Land Use Planning
Yorkshire Water Services Ltd
Midway
Western Way
Halifax Road
Bradford
BD6 2LZ

Your Ref: 2015/62/90435/E
Our Ref: R003880

10th April 2015

Parkham Foods Ltd, 22 Halifax Road, Liversedge - Erection of 14 dwellings with integral garages

Client:	Swift Property Management and Consultancy	
Project:	Former Parkam Foods Site Residential Development	
Drawing:	Site Layout	
Date:	Feb 2015	Scale: 1:500@A3
Drawing No:	1434/110	Rev: C

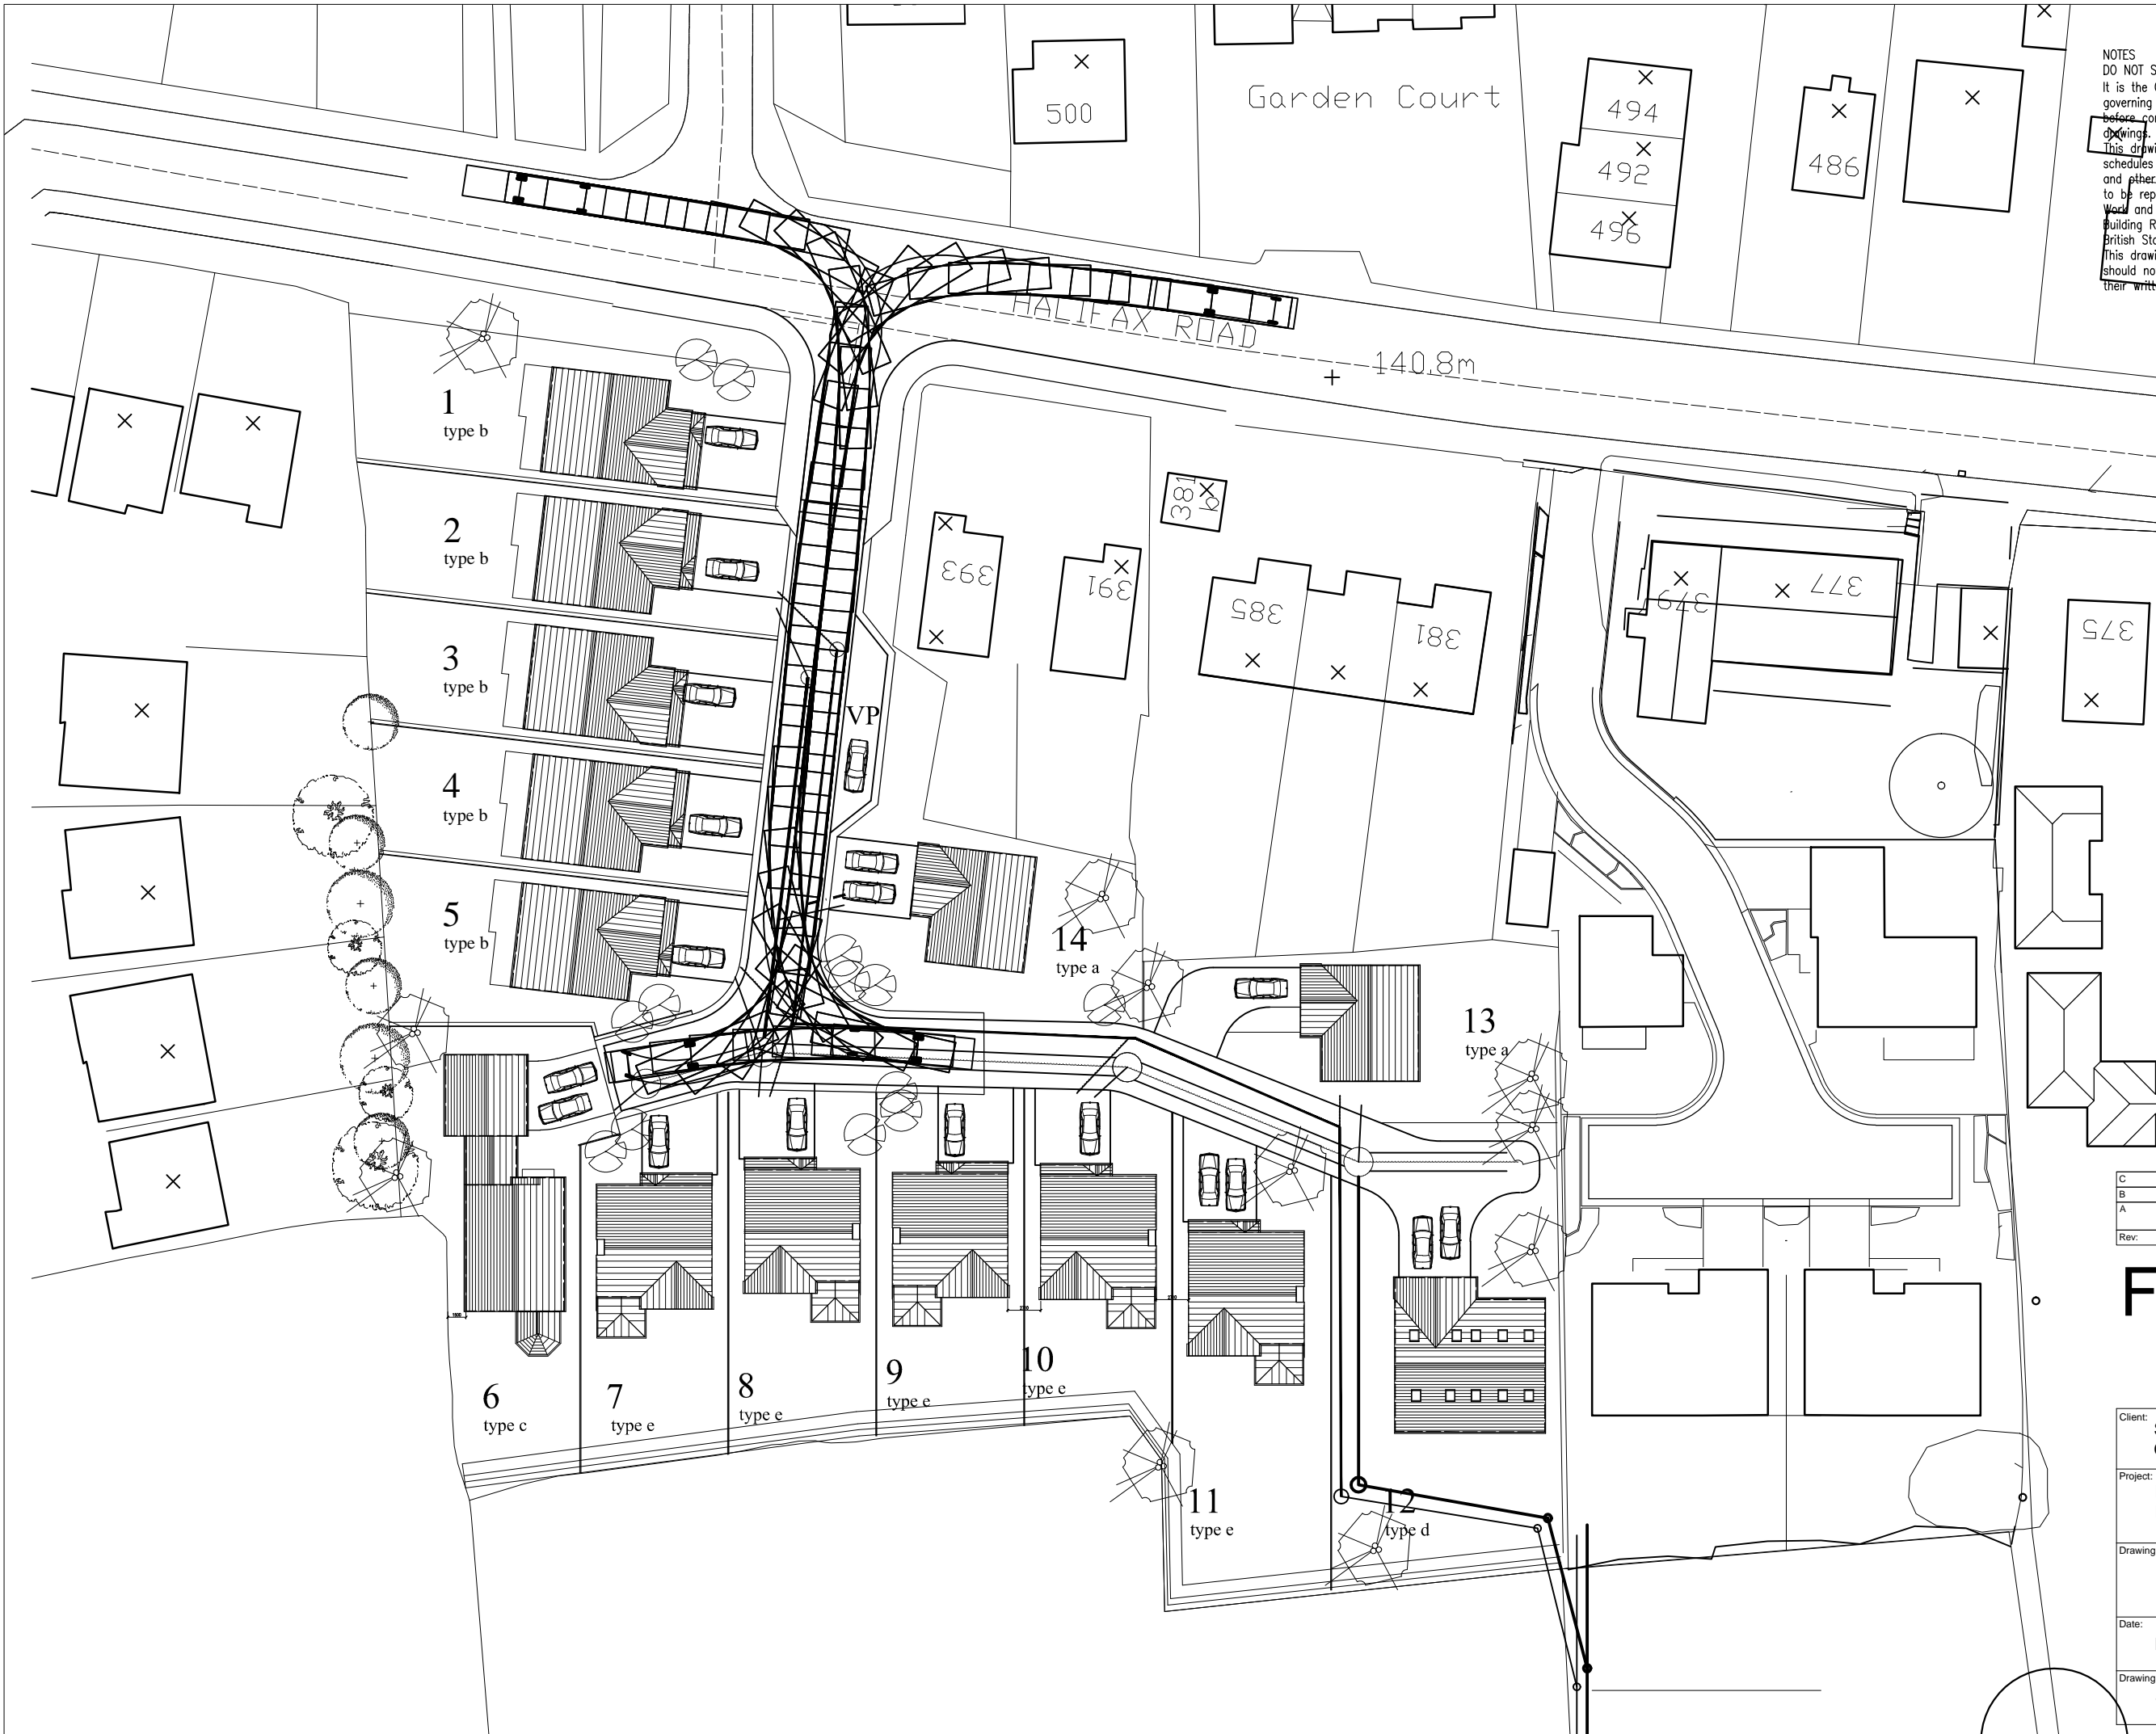
FOUL WATER - The development of the site should take place with separate systems for foul and surface water drainage.

Foul water domestic waste may discharge to the 225mm diameter public foul water sewer recorded in private lands to the south, at a point approximately 80 metres from the site.

Alternatively, foul water domestic waste may discharge to the 375mm diameter public foul/combined water sewer recorded in Halifax Road, at a point approximately 5 metres from the site, however, in this case a pumped connection will be required. The peak pumped foul water discharge must not exceed 6 (six) litres per second.

SURFACE WATER - Sustainable Systems (SUDS), for example the use of soakaways and/or permeable hardstanding, may be a suitable alternative solution for surface water disposal that is appropriate in this situation.

The developer is also advised to contact the relevant drainage authorities with a view to establishing a suitable watercourse for the disposal of surface water. **It is understood that a watercourse (Clough Beck) is located to the south of the site.**

No land drainage to be connected/discharged to public sewer.

**No development shall take place until details of the proposed means of disposal of foul and surface water drainage, including details of any balancing works and off-site works, have been submitted to and approved by the local planning authority.
(To ensure that the development can be properly drained.)**

**Unless otherwise approved in writing by the local planning authority, there shall be no piped discharge of surface water from the development prior to the completion of the approved surface water drainage works and no buildings shall be occupied or brought into use prior to completion of the approved foul drainage works.
(To ensure that no foul or surface water discharges take place until proper provision has been made for their disposal.)**
